**CITY OF PORTLAND, MAINE
DEVELOPMENT REVIEW APPLICATION
PLANNING DEPARTMENT PROCESSING FORM**

2005-0037
Application I. D. Number

Alice Ct Single Family Home
Project Name/Description

RE: Application for Single Family Residence, 7 Alice Court

**AUBURN PINES**

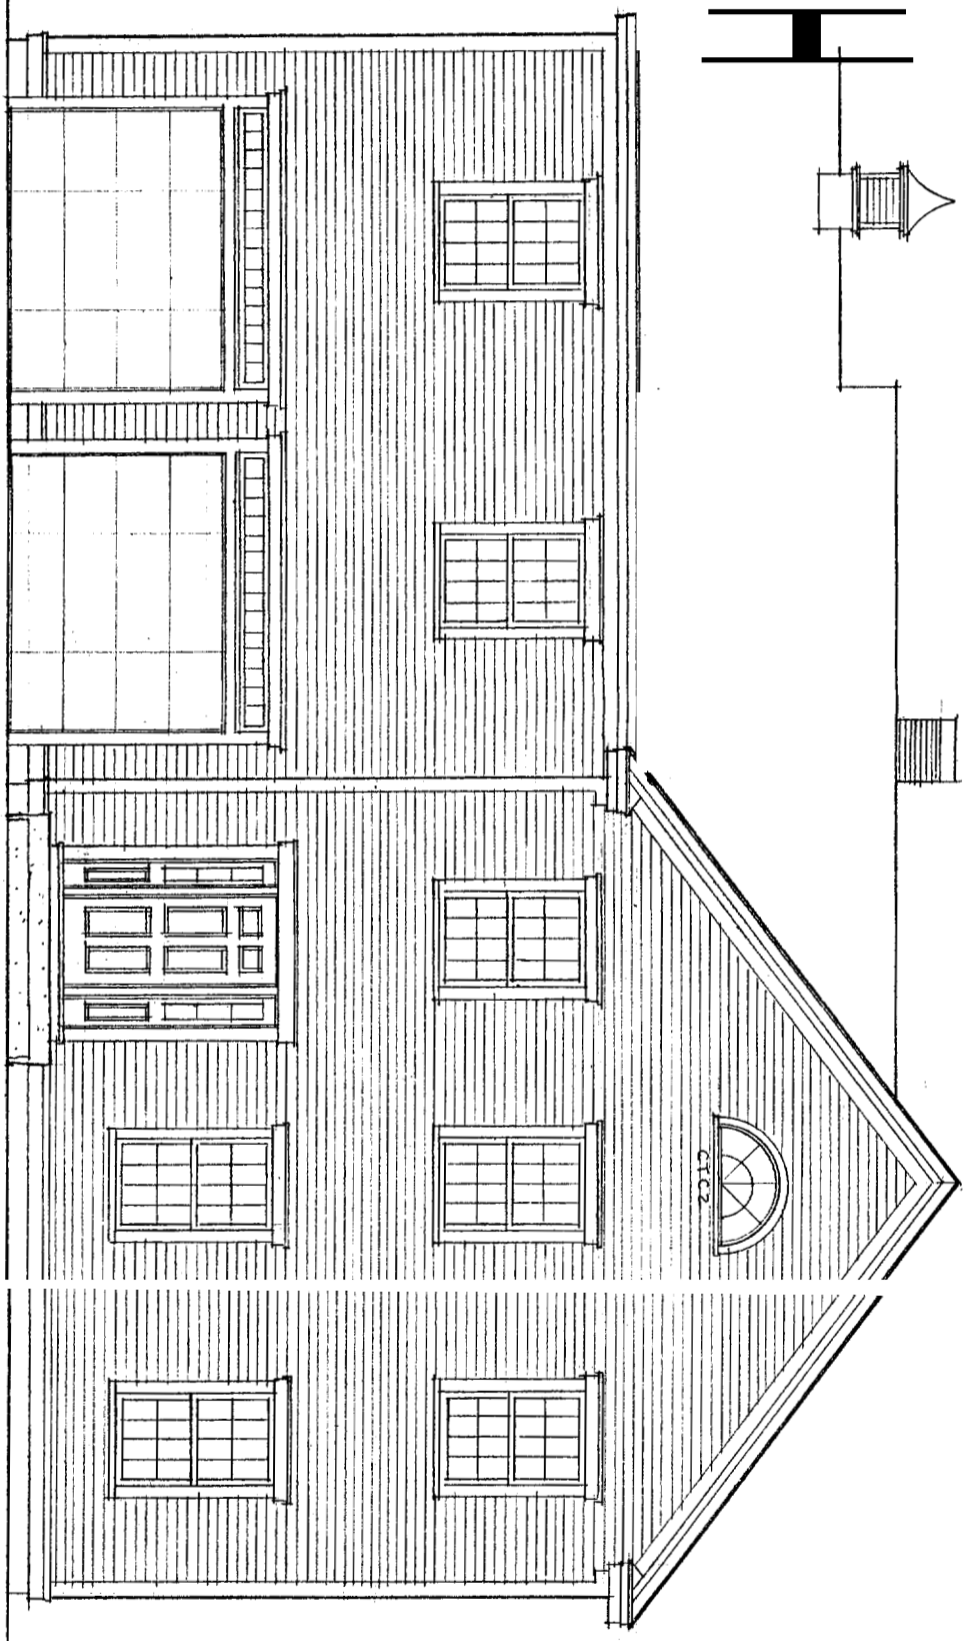
- a. Please revise the site plan to show any proposed topography changes. The submitted site plan shows no change in grades, which indicates a front yard graded back toward the building and also indicates a daylight basement in the rear. The building elevations do not reflect this.
- b. One of the required street trees appears to be directly in front of the entrance, approximately 3 feet from the house. Please relocate this tree so that it is along the street frontage/property line.

Section 14-80(d)3 of the Zoning ordinance requires a minimum of fourteen (14) feet from the property line to a two story building. I am scaling only twelve (12) feet from the property line to the left side of the building.

Section 14-80(f) requires a minimum lot width of eighty (80) feet. I am scaling sixty-five (65) feet through the narrowest part of the lot where the principal structure is placed. Lot width is defined as the distance parallel to the front of the building measured between side lot lines through that part of the principal building where the lot is narrowest.
